Recommendation Report for Planning Permission for Works or Extension to a Dwelling

REF NO: BR/116/20/HH

LOCATION: 3 Gordon Avenue West
Bognor Regis
PO22 9LQ

PROPOSAL: Erection of single storey extension

Drawing Title
Prop. Ground Floor - 45 deg code

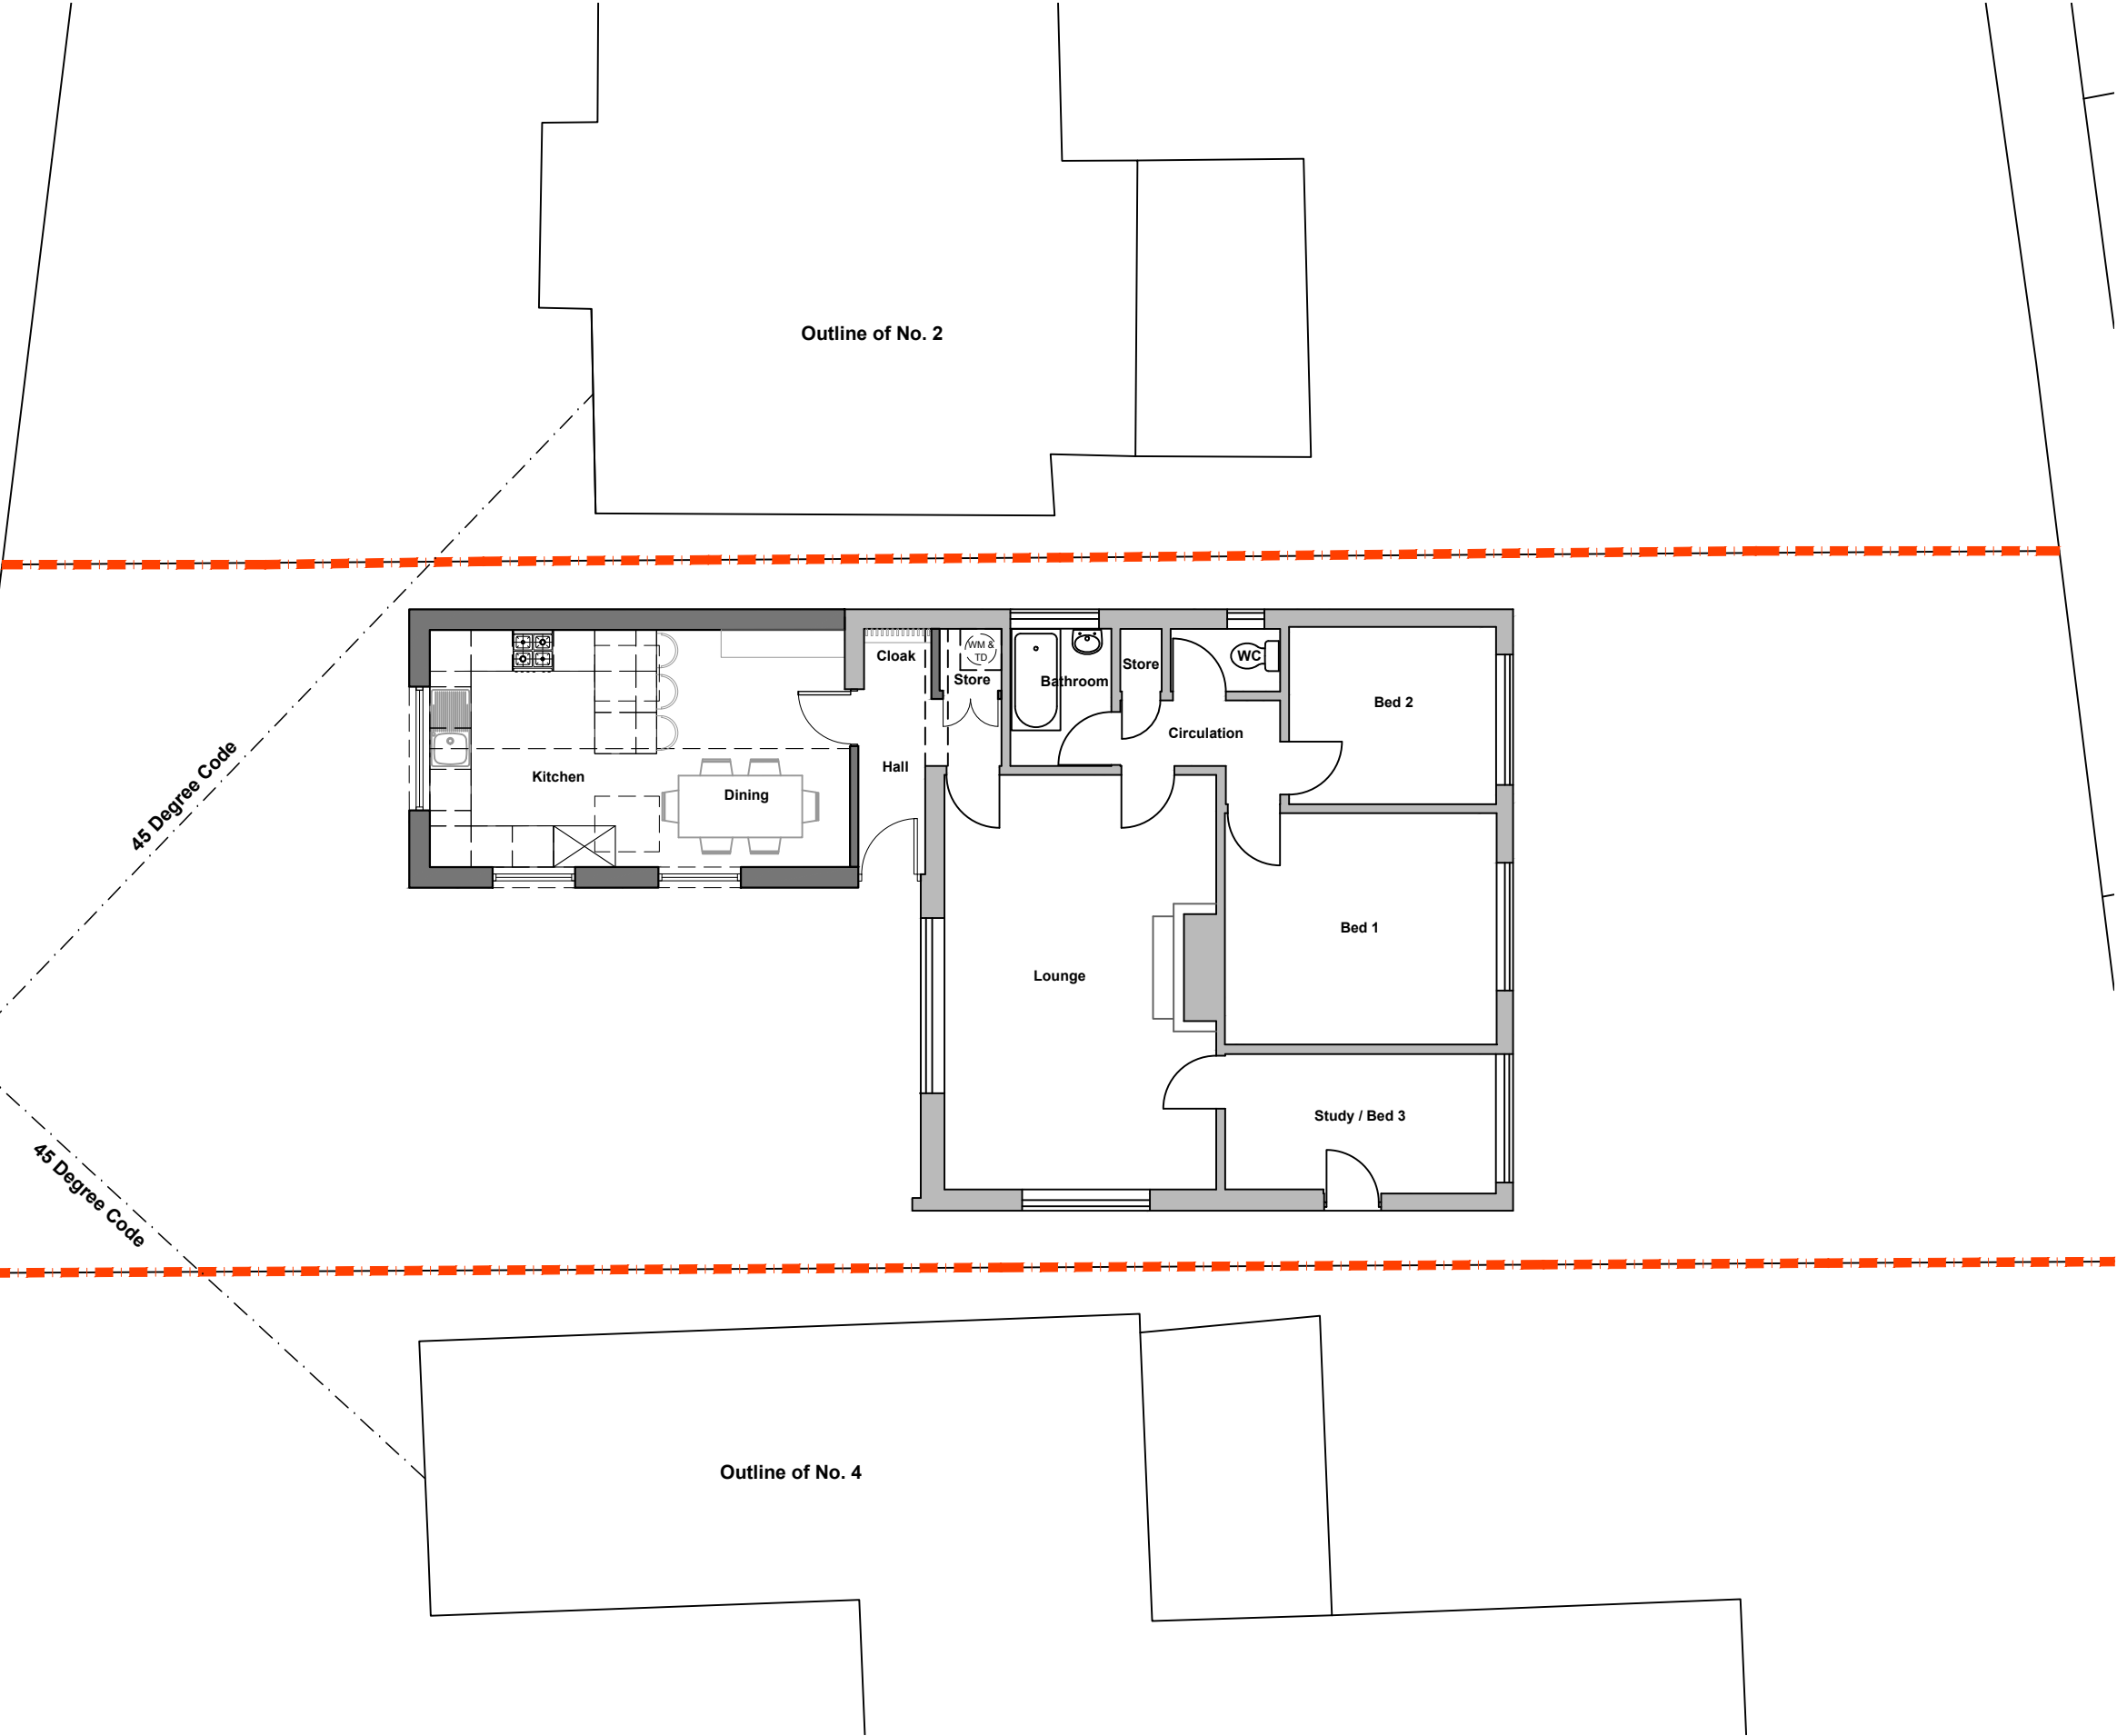
The extension replaces a garage and alters the roof from flat to pitched. It will increase in height from 2.1m to approximately 3.8m. The depth will increase by around 1m to the front boundary and as a result the addition running along the northern boundary it will likely provide some minor overshadowing to the front facing southern window of the neighbour at No.2. The extension is not considered to intersect a 45 degree line when drawn from the centre of the window towards the boundary and any impacts as a result are not considered significant.

Proposed Elevations

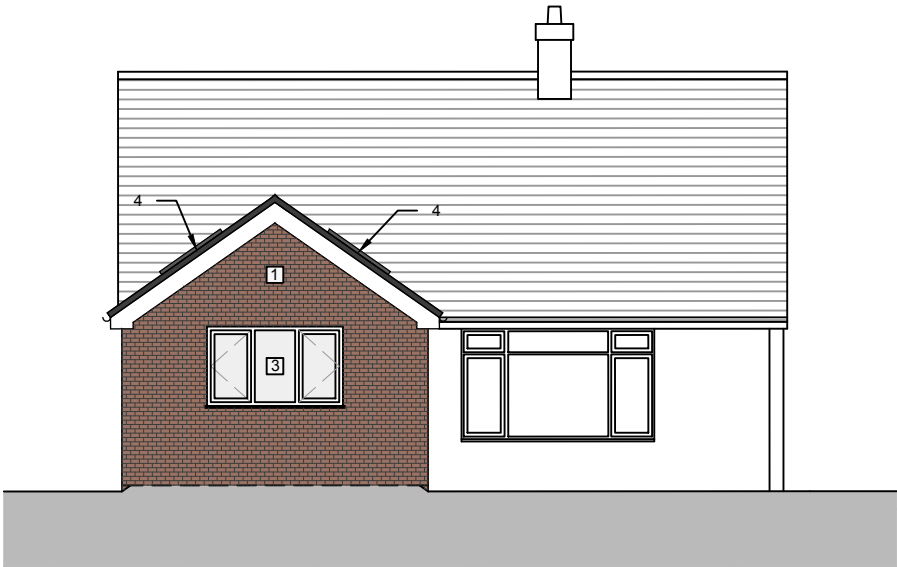
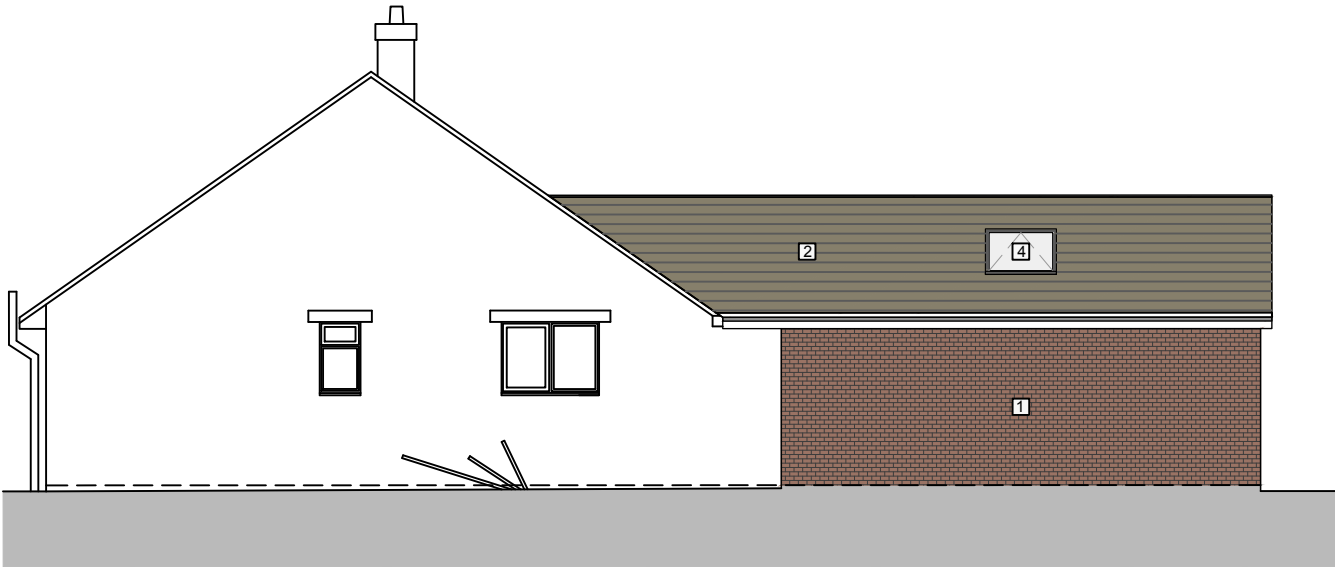
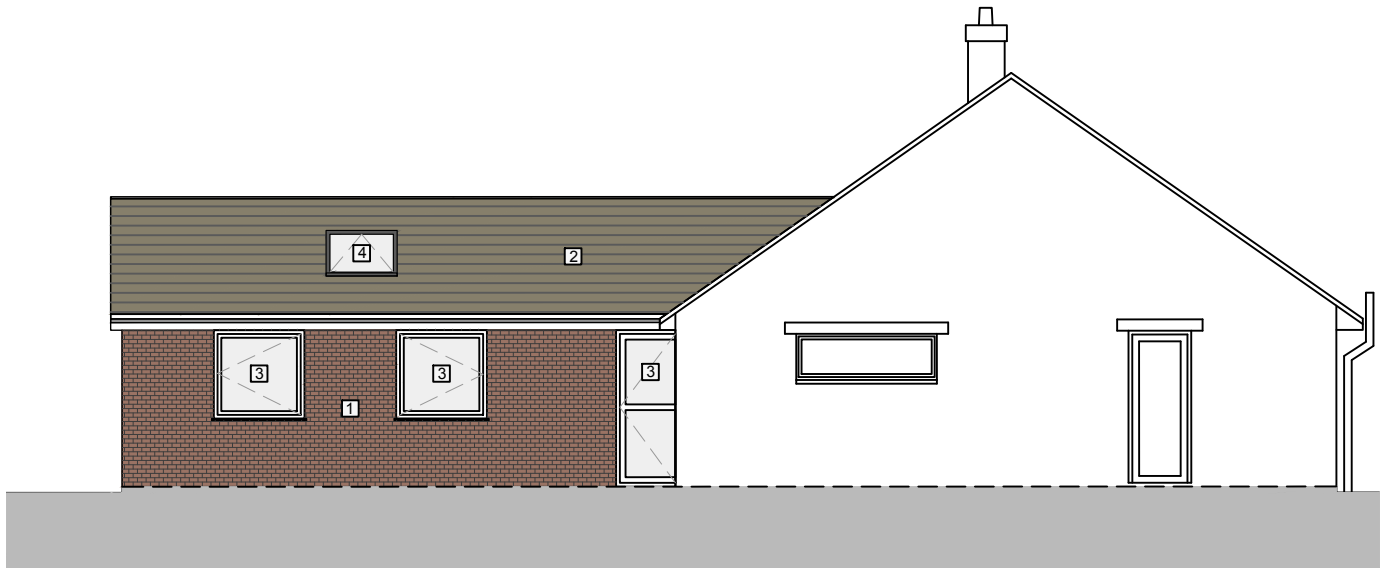
The development extends from the principal elevation and is highly visible from the street scene.

There is a flat roof garage however the proposal increases its depth and constructs a pitched roof.

The proposal adds bulk to the front of the dwelling, with the garage more visually dominant than the existing. The neighbouring property at No.4 has a similar development and whilst large, it is not considered out of character.

The extension consists of red brick, this is the same as the existing garage and again is acceptable.

Whilst the addition alters the appearance of the dwelling in the street scene, it is not considered to adversely impact the spatial pattern of the property within the area and accord with D DM1 and D DM4 of the Arun Local Plan

Due to the siting of the property at No.4 the proposal is not considered to give rise to adverse impacts on this elevation. There will be two ground floor windows will face the south elevation however with 5m to the boundary and with no side windows to the extension at No.4, it is not considered to give rise to adverse overlooking. There will be 2 velux however due to their height above floor level again are not deemed to give rise to overlooking.
